OUT18/4218

**Cadia East Project – Molybdenum Recovery Plant Relocation (MP 06_0295 MOD 10)
Comment on the Environmental Assessment**

Figure 3

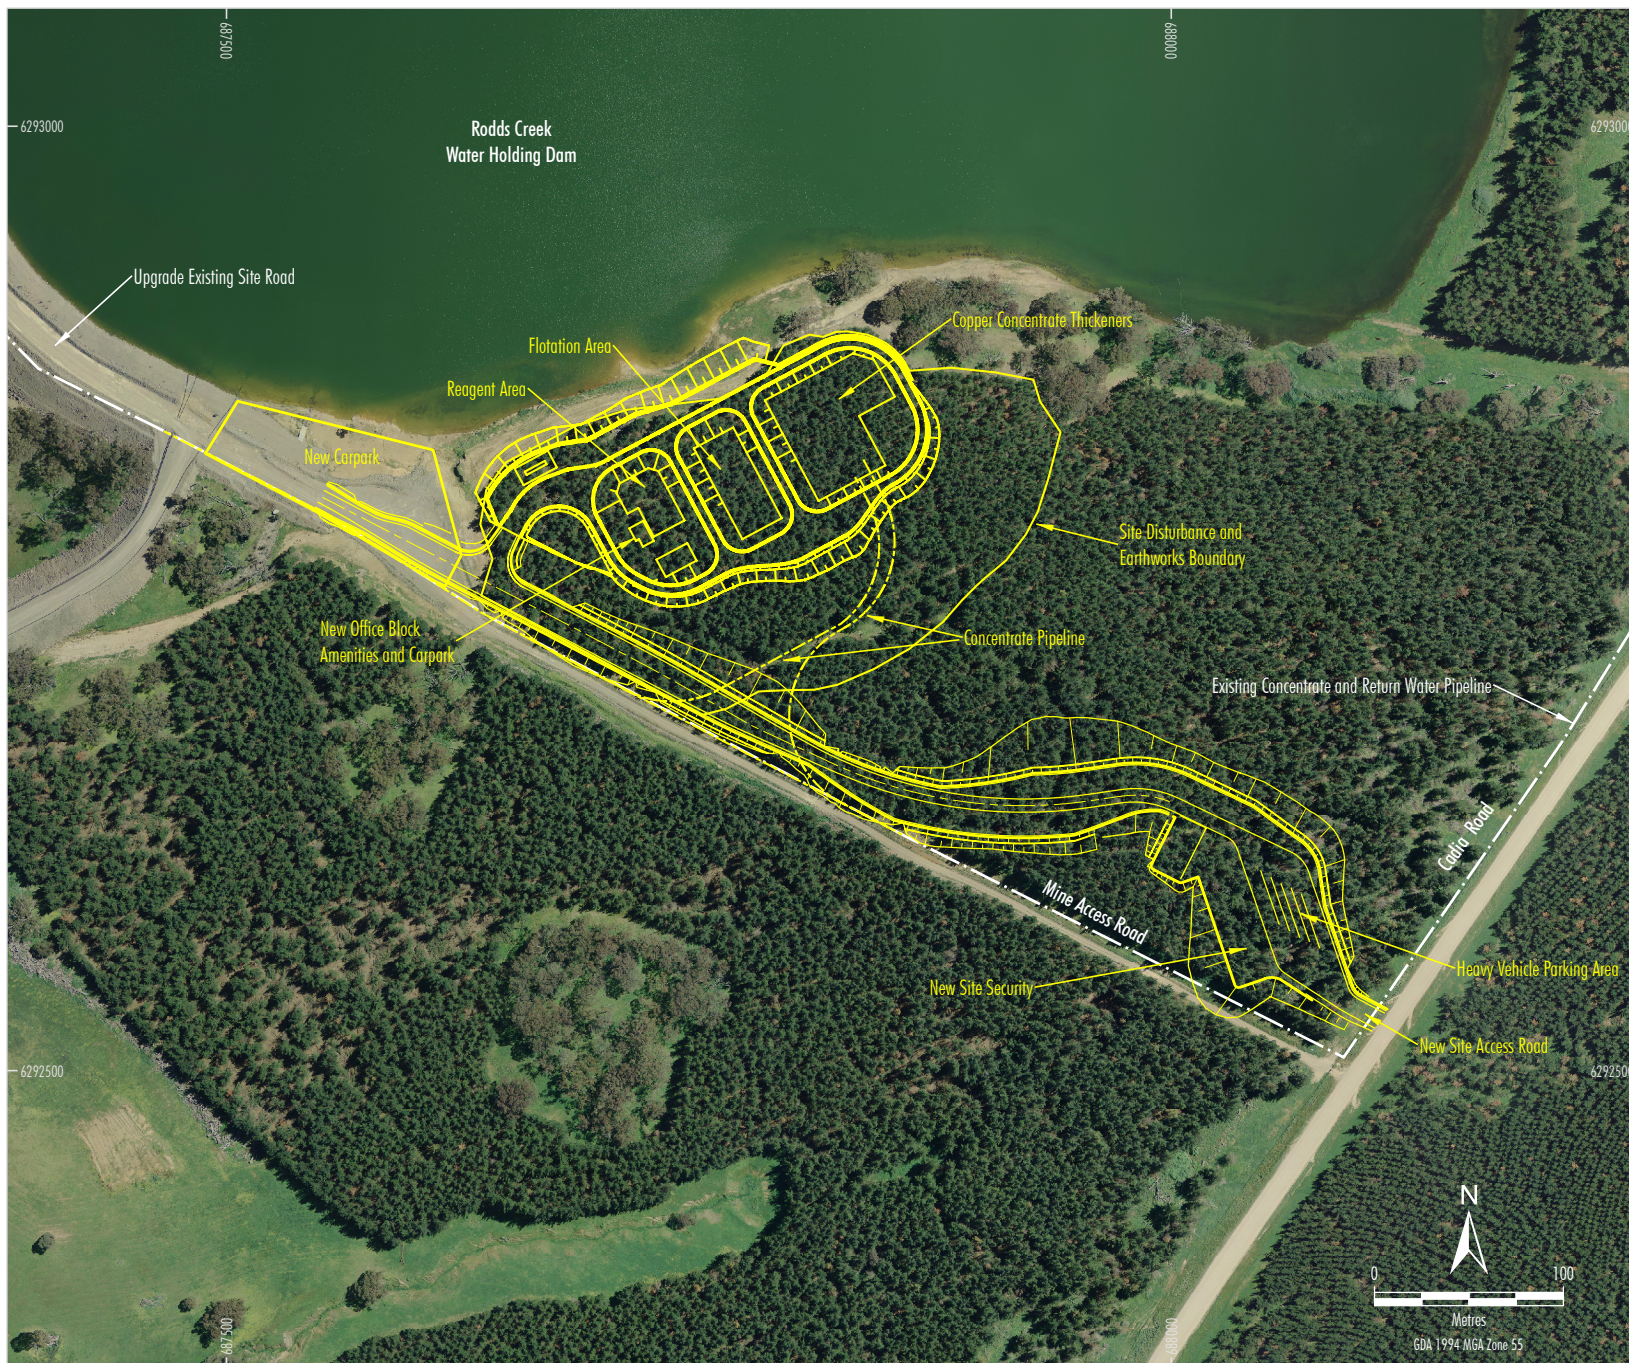
- Erosion and sediment control issues should be managed in accordance with the guideline, Managing Urban Stormwater: Soils and Construction (Landcom 2004).
- A 30m vegetated buffer should be established between the proposed works and the full supply level of Rodds Ck Dam in accordance with the [Guidelines for Controlled Activities on Waterfront Land](#) (DPI 2012).
